Recommendation Report for Planning Permission for Works or Extension to a Dwelling

REF NO: BR/115/26/HH

LOCATION: 32 Pevensey Road
Bognor Regis
PO21 5NU

PROPOSAL: First floor extension.

South West Elevation

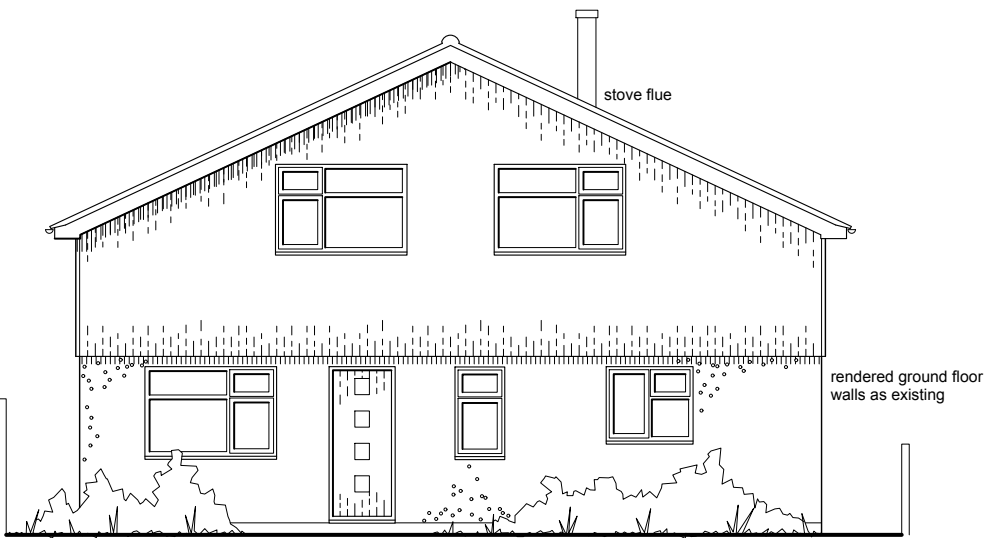
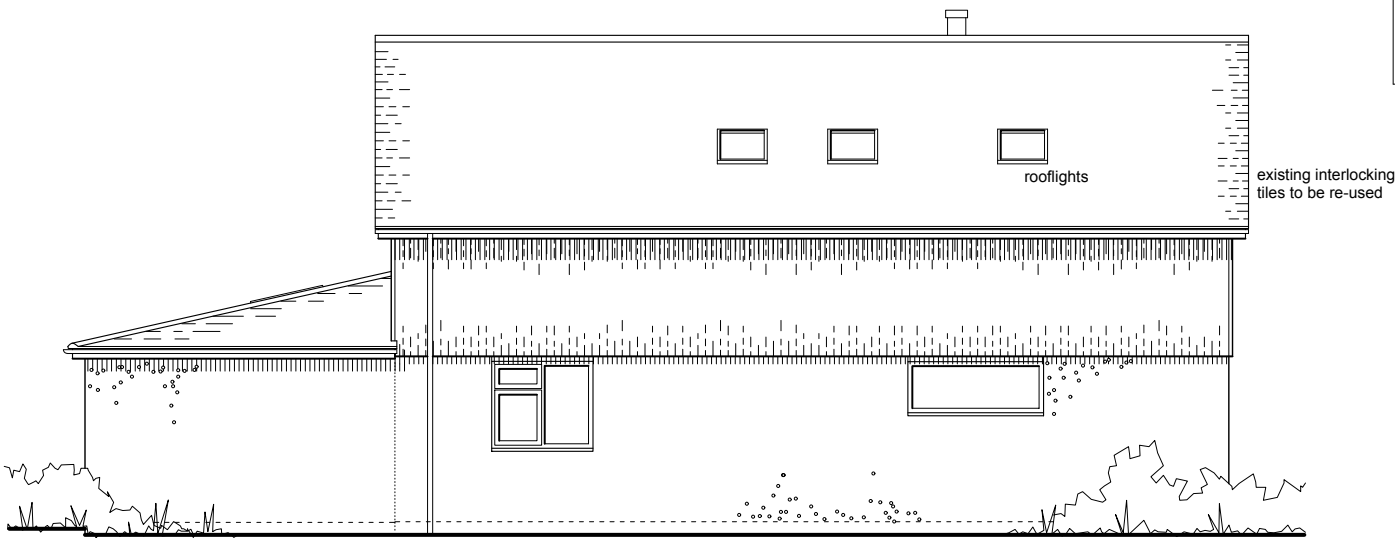
The proposed fenestration would include two windows within the front (south-west) elevation, three Velux rooflights within the north-west side roof slope, a window within the rear (north-east) elevation, and a single Velux rooflight within the south-east side roof slope.

The proposal would increase the existing ridge height by approximately 1.6m, resulting in a noticeable increase in the overall bulk and massing of the dwelling. Consequently, the property would be perceived as a two-storey dwelling and the extension would not represent a subservient addition, contrary to the guidance contained within the Arun Design Guide (ADG). Nevertheless, the surrounding street scene is characterised by a varied mix of dwelling types, roof forms and building heights. In this context, the increased scale of the dwelling would not appear incongruous or out of keeping with the prevailing character of the area. Furthermore, the extension would not project beyond the existing building line and the use of matching materials would ensure visual integration with the host dwelling. Accordingly, the proposal would be acceptable and in accordance with Arun Local Plan (ALP) policy D DM1.

All proposed fenestration would be newly introduced, as there are currently no openings at first floor level. The south-west openings would overlook the front garden and are separated from neighbouring properties by the highway, thereby limiting any opportunity for overlooking or loss of privacy.

Rooflights proposed within the north-west side elevations would have views towards the block of flats and due to their position and angle would not afford direct views towards neighbouring properties.

First Floor Plan

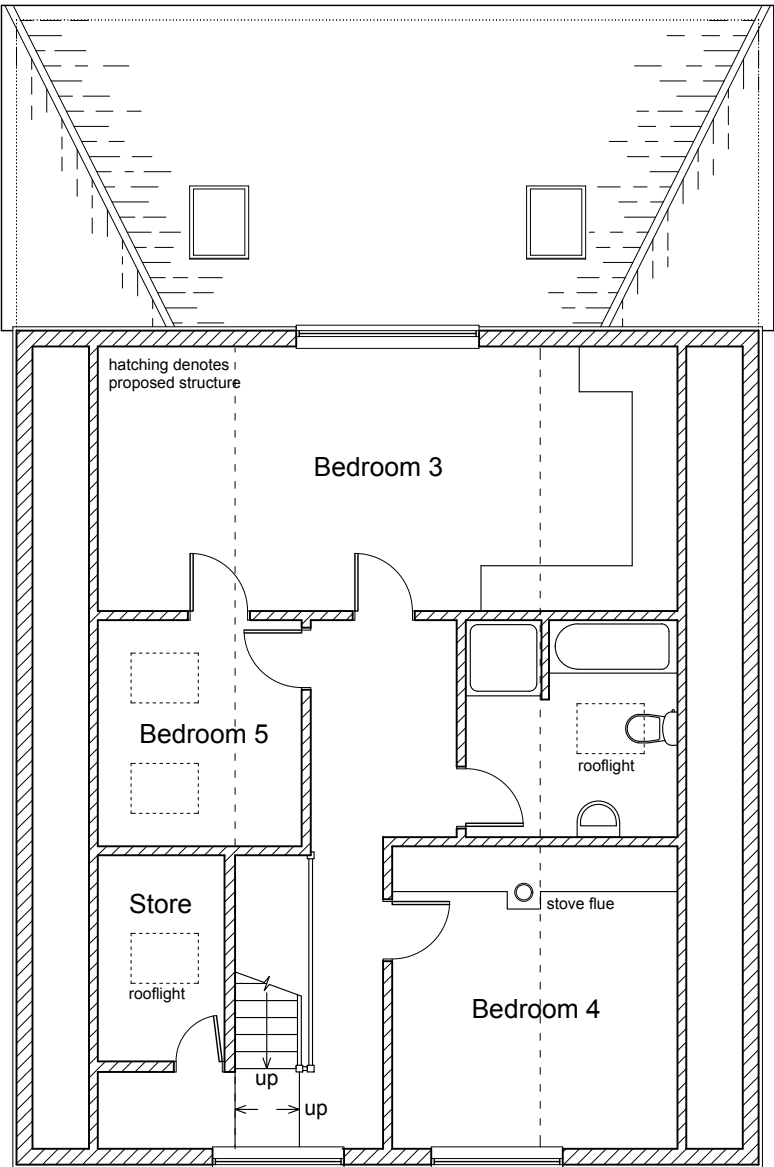
The proposed extension would be constructed above the existing ground-floor footprint of the dwelling and would measure approximately 10m in width and 11m in depth. The development would incorporate a pitched roof design with a maximum ridge height of approximately 6.6m and an eaves height of approximately 3.9m. External materials would comprise render, painted brickwork and vertical boarding to match the appearance of the existing dwelling. Existing concrete roof tiles would be retained and reused to ensure consistency with the host property.

The proposed extension would be set in approximately 1m from the neighbouring boundary to the west. A block of flats is located beyond this boundary, with additional separation provided by a pathway and existing vegetation. To the east, the extension would be set in approximately 1m from the shared boundary. The flank-to-flank separation distance to the neighbouring dwelling to the east would be approximately 3.2m.

North East Elevation

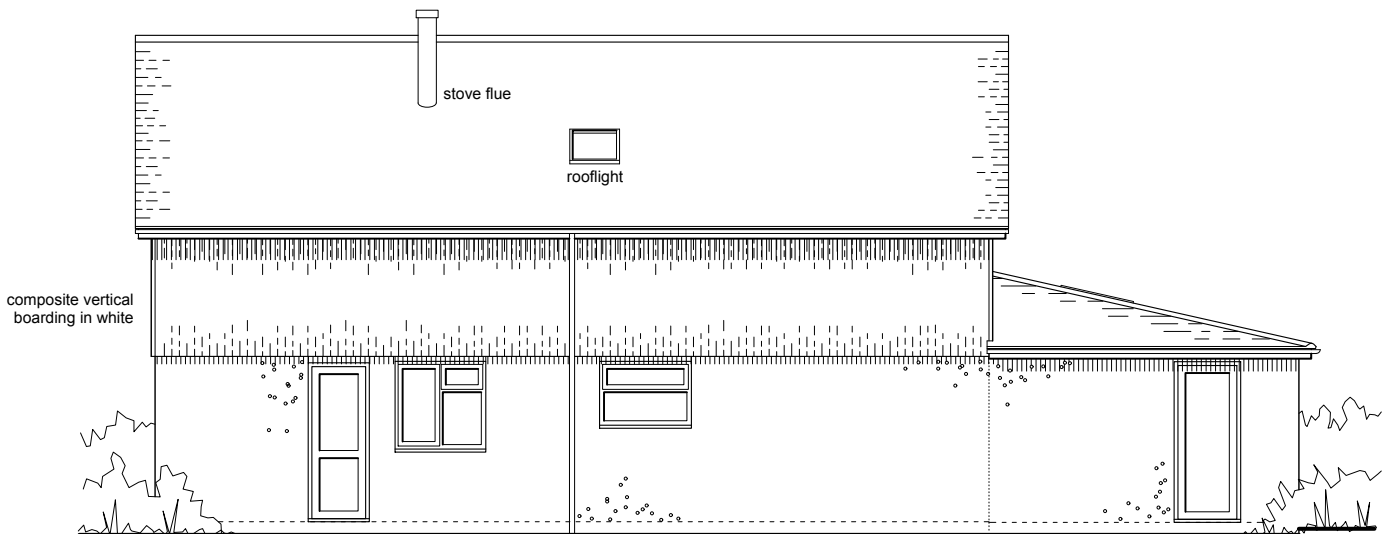
The proposed north-east window would overlook the private rear garden and the adjoining school grounds beyond. There are no residential properties immediately to the rear of the site, and as such the window would not result in unacceptable overlooking or loss of privacy.

Similarly, the proposed rooflight within the south-east roof slope would not afford direct views towards the neighbouring property to the east. Furthermore this window would serve a non-habitable room and therefore not to give rise to harmful overlooking.
